Recommendation Report for Planning Permission for Works or Extension to a Dwelling

REF NO: WA/60/15/HH

LOCATION: 6 Nash Way
Walberton

PROPOSAL: First floor side extension (resubmission following WA/50/15/HH).

## Proposed Elevations

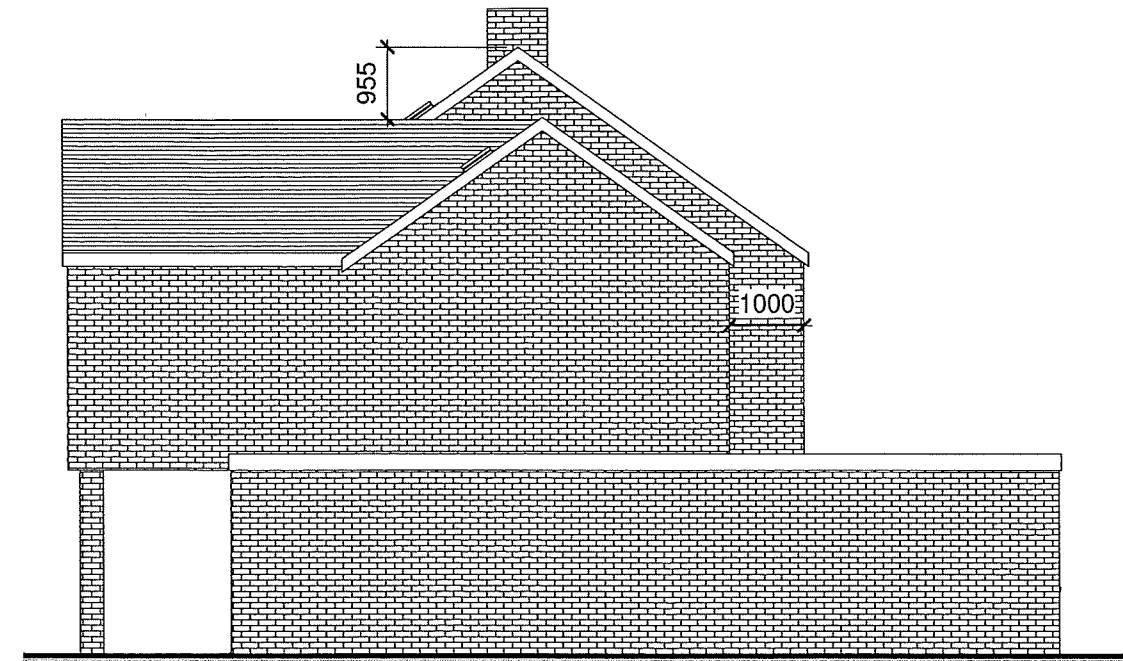
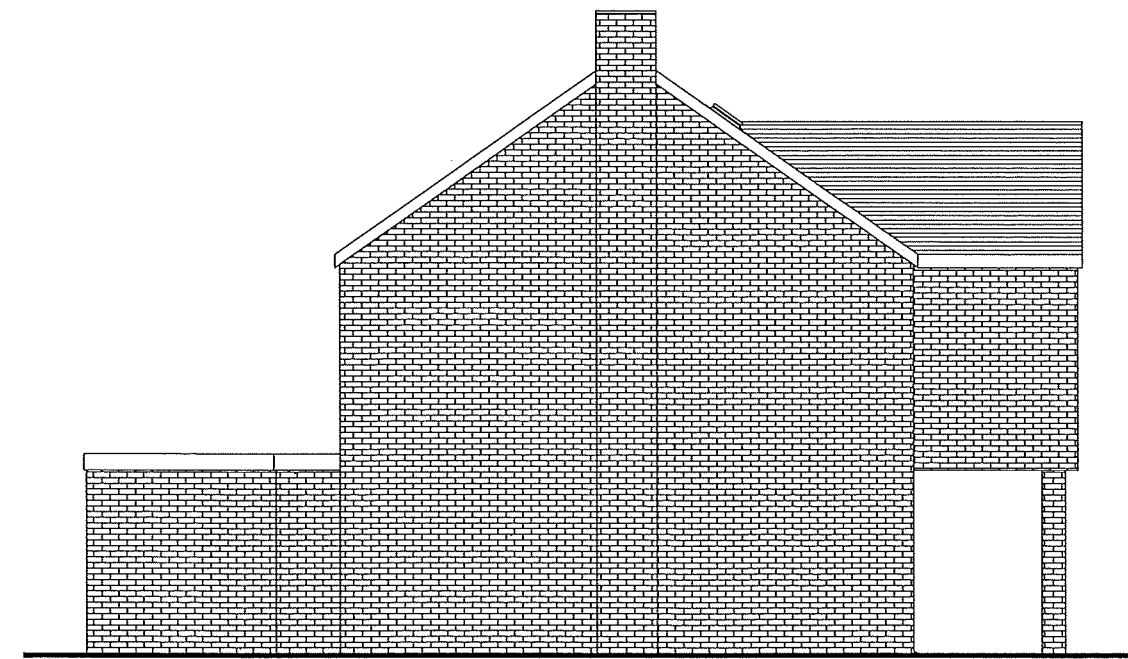
A Juliet balcony is proposed in the rear elevation which cannot be stood on. It would not increase the amount of overlooking above that which would result from an upstairs window and would not result in direct overlooking of neighbouring properties.

The amended plans show a reduction in height of the ridge of the extension which is now almost 1m below the ridge of the existing dwelling. The size of the gable has also been reduced to accommodate a set back of 1m from the front elevation of the dwelling. This has reduced harm to the outlook and overbearing impacts on the neighbouring property. It is now considered that there would be no materially adverse impact on the residential amenities of the neighbouring dwelling.

First Floor

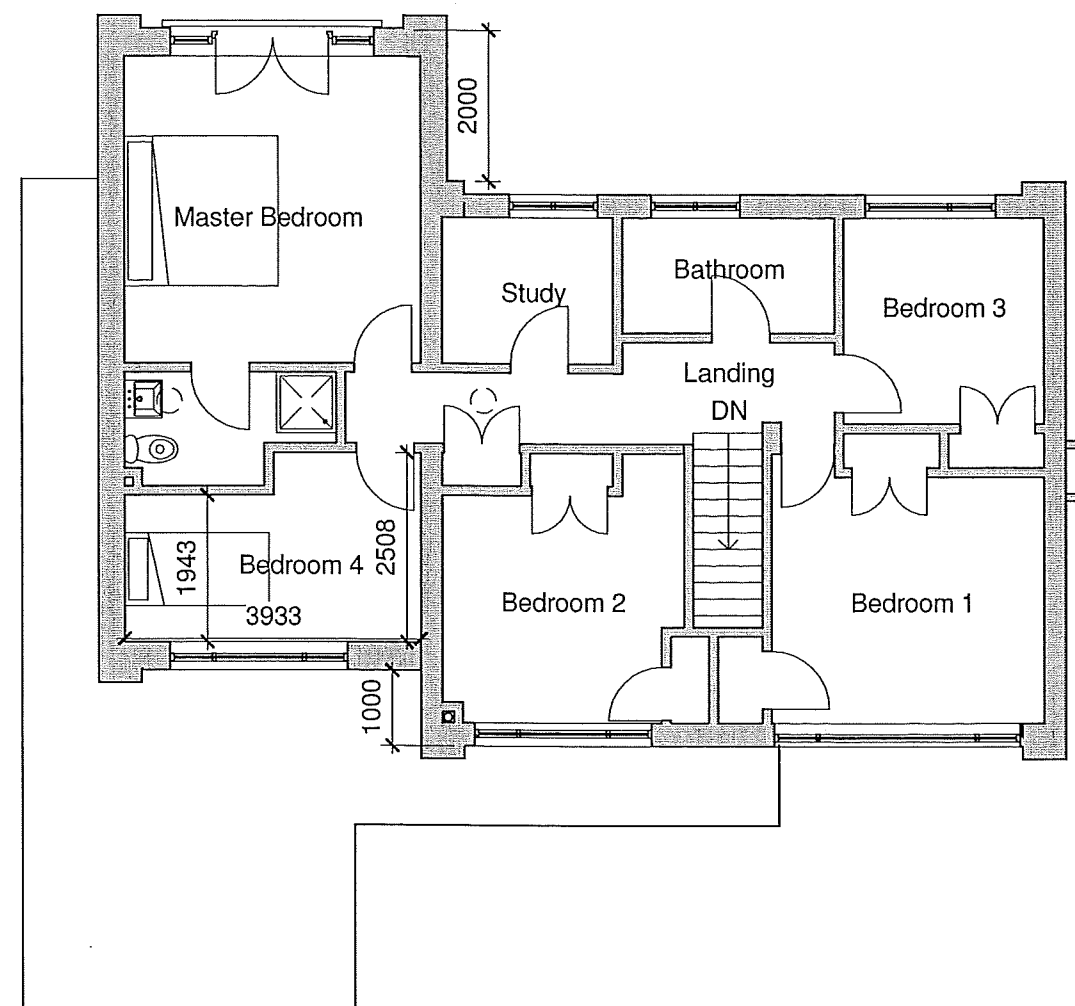
The loss of light to the neighbour's side windows would not result in material harm. The windows either do not serve habitable rooms, are secondary or located an acceptable distance from the boundary. The first floor extension would be located 1m from the boundary and 6m from the dining room window which faces onto the boundary fencing and side wall of the garage already.

The only property that would be affected by the proposal is no 7 to the north and an objection has been received from these neighbours. The extension is located to the side of the existing property at first floor above the flat roofed garage. It would retain a gap of 1m to the boundary and a gap of 6m to the side elevation of the neighbouring dwelling. Given the size, height and position of the extension it is not considered that the proposal would have a materially adverse overbearing or overlooking effect. A condition is suggested to ensure that no additional windows are provided in the side elevation of the extension which could result in adverse overlooking.
